TO: Stuart Coles, juwi, Inc.
FROM: Susan Nordstrom, Project Manager
DATE: April 18, 2018
RE: Palmer Solar Project Environmental Survey Findings

WSEO-18-001

RE: Wildlife, Wetland, and Cultural Resource Surveys at the Proposed Palmer Solar Project in El Paso County, Colorado

05
WSEO Area Allocation Map

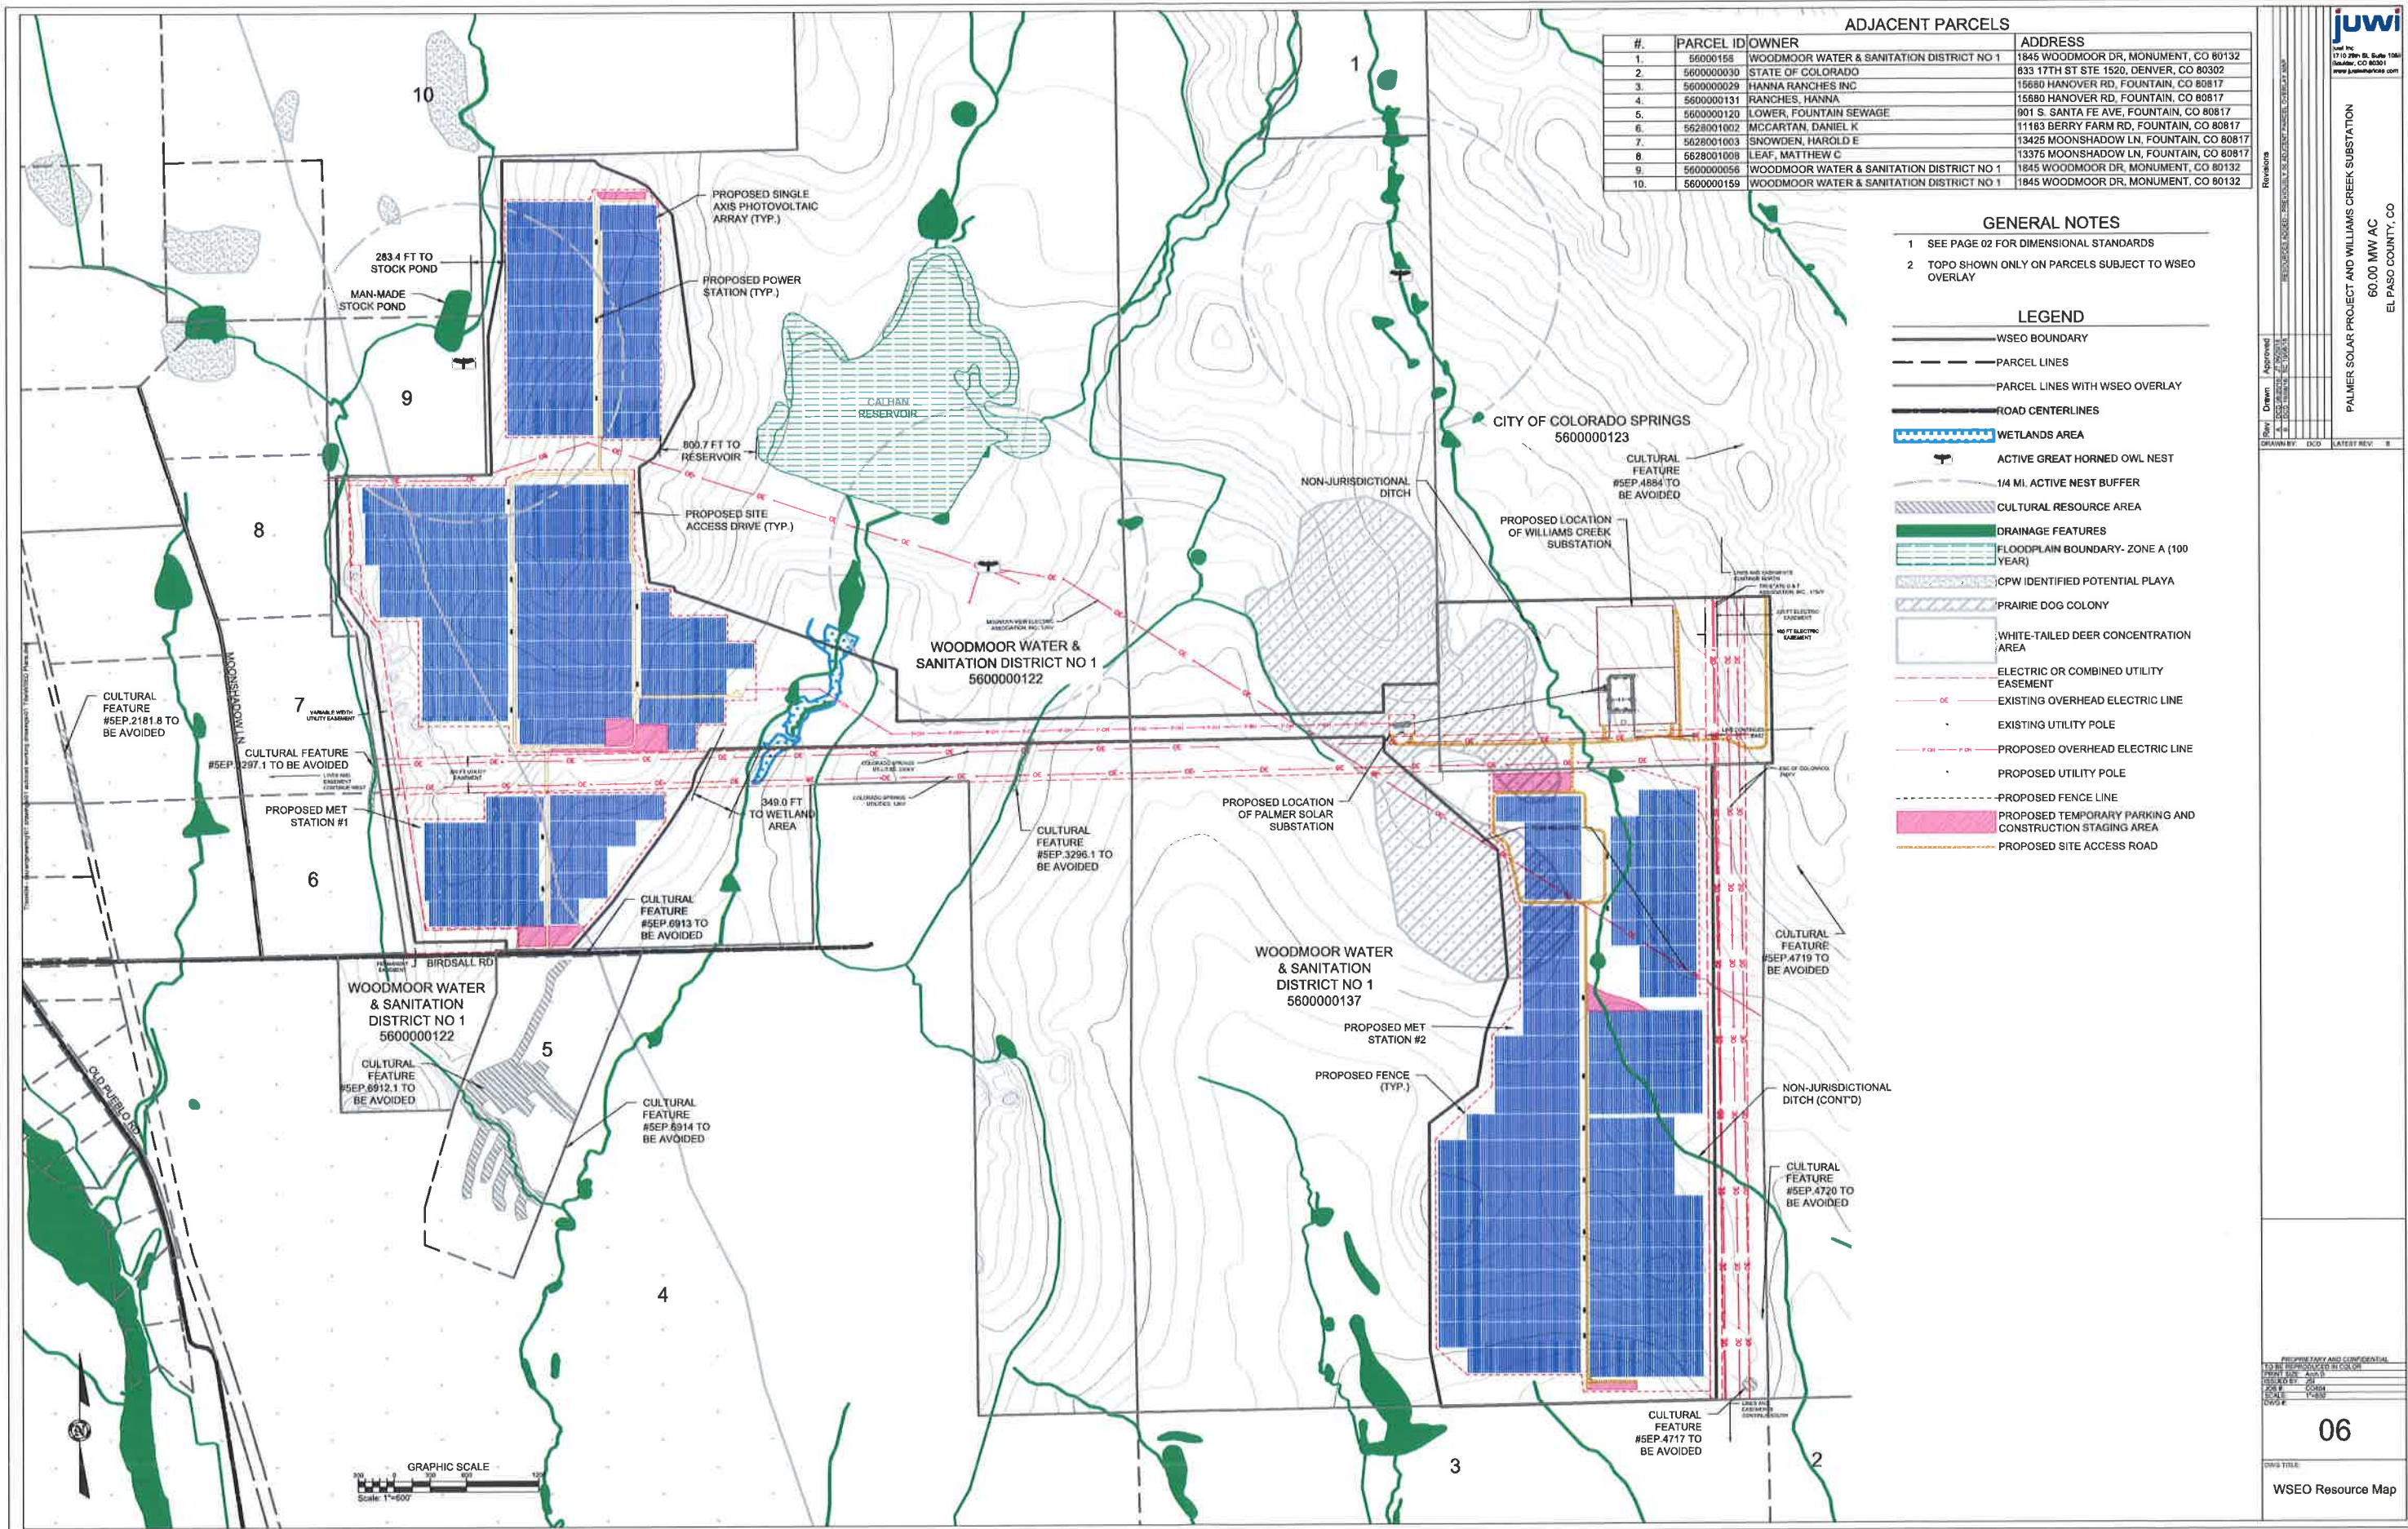
Identify buffer on WSEO map

identify on the WSEO map so avoidance can occur

identify seasonal buffer on WESO Map

verify potential wetland and ponded areas is mapped on WSEO map plan-

Didn't the Core state no permit required for the two power poles- No permit was requested for the remainder of the site.? Map pond areas on WSEO map- Preservation of natural features and habitat is a component of the Policy Plan.

Verify floodplain mapping is correct on WSEO map plan

clearly identify all streams, drainage ways on WSEO map
